Planning consultation: Erection of agricultural barn, storage container, portacabin office, rainwater harvesting tank and associated access track

Location: Land North East Of Holts Farm Mansmoor Road Charlton On Otmoor

Objection – further information required

Title: Figure 1

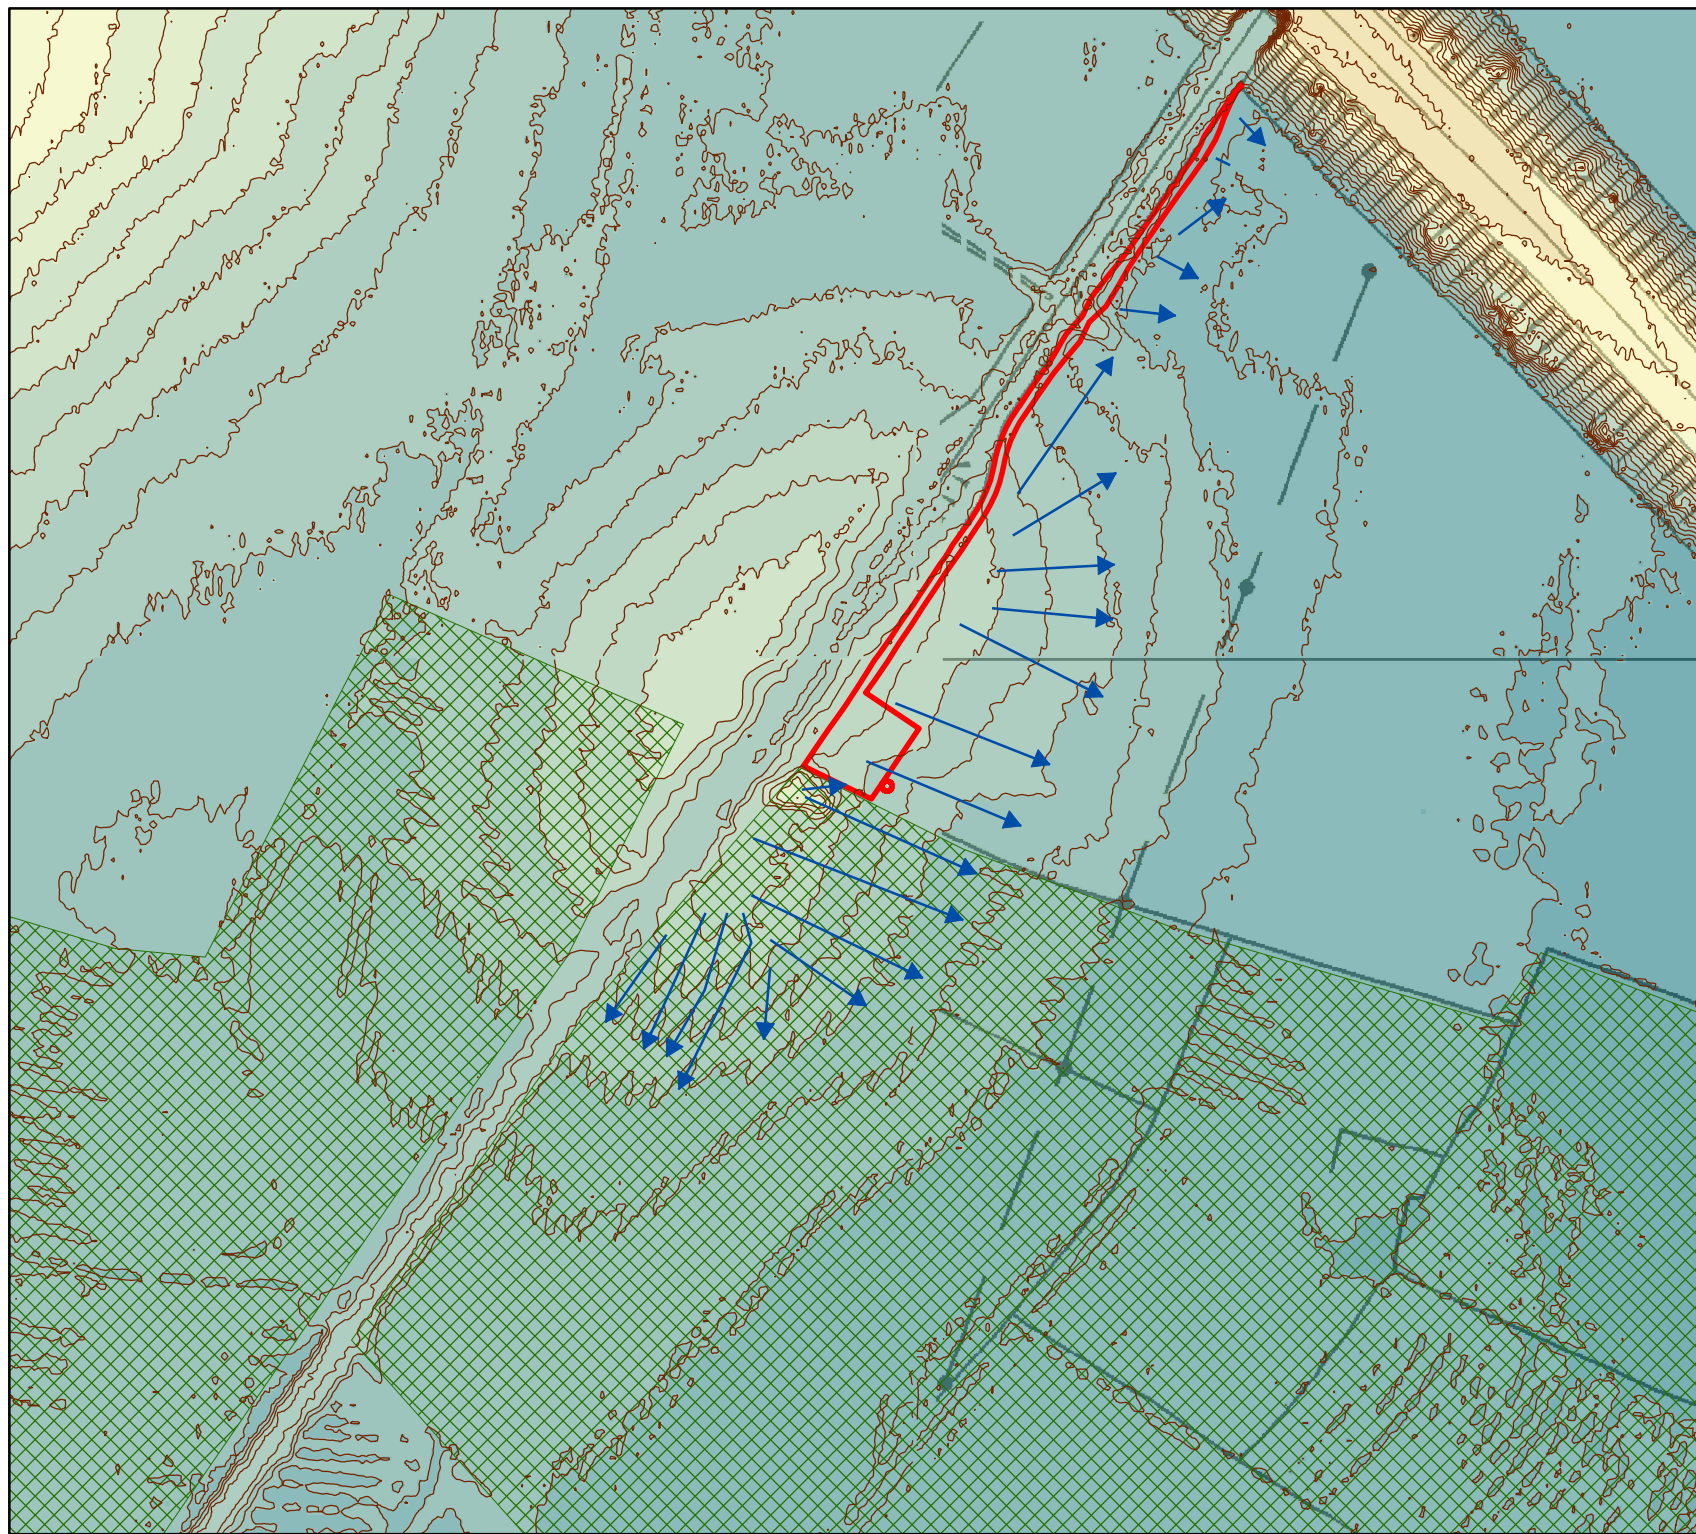
The last bullet point under 4.2. of the Wallingford Hydrosolutions Limited report states that 'Long term drainage from the hardstanding and barn would be directed away from the SSSI.' Some detail of the proposed drainage is needed to justify this statement.
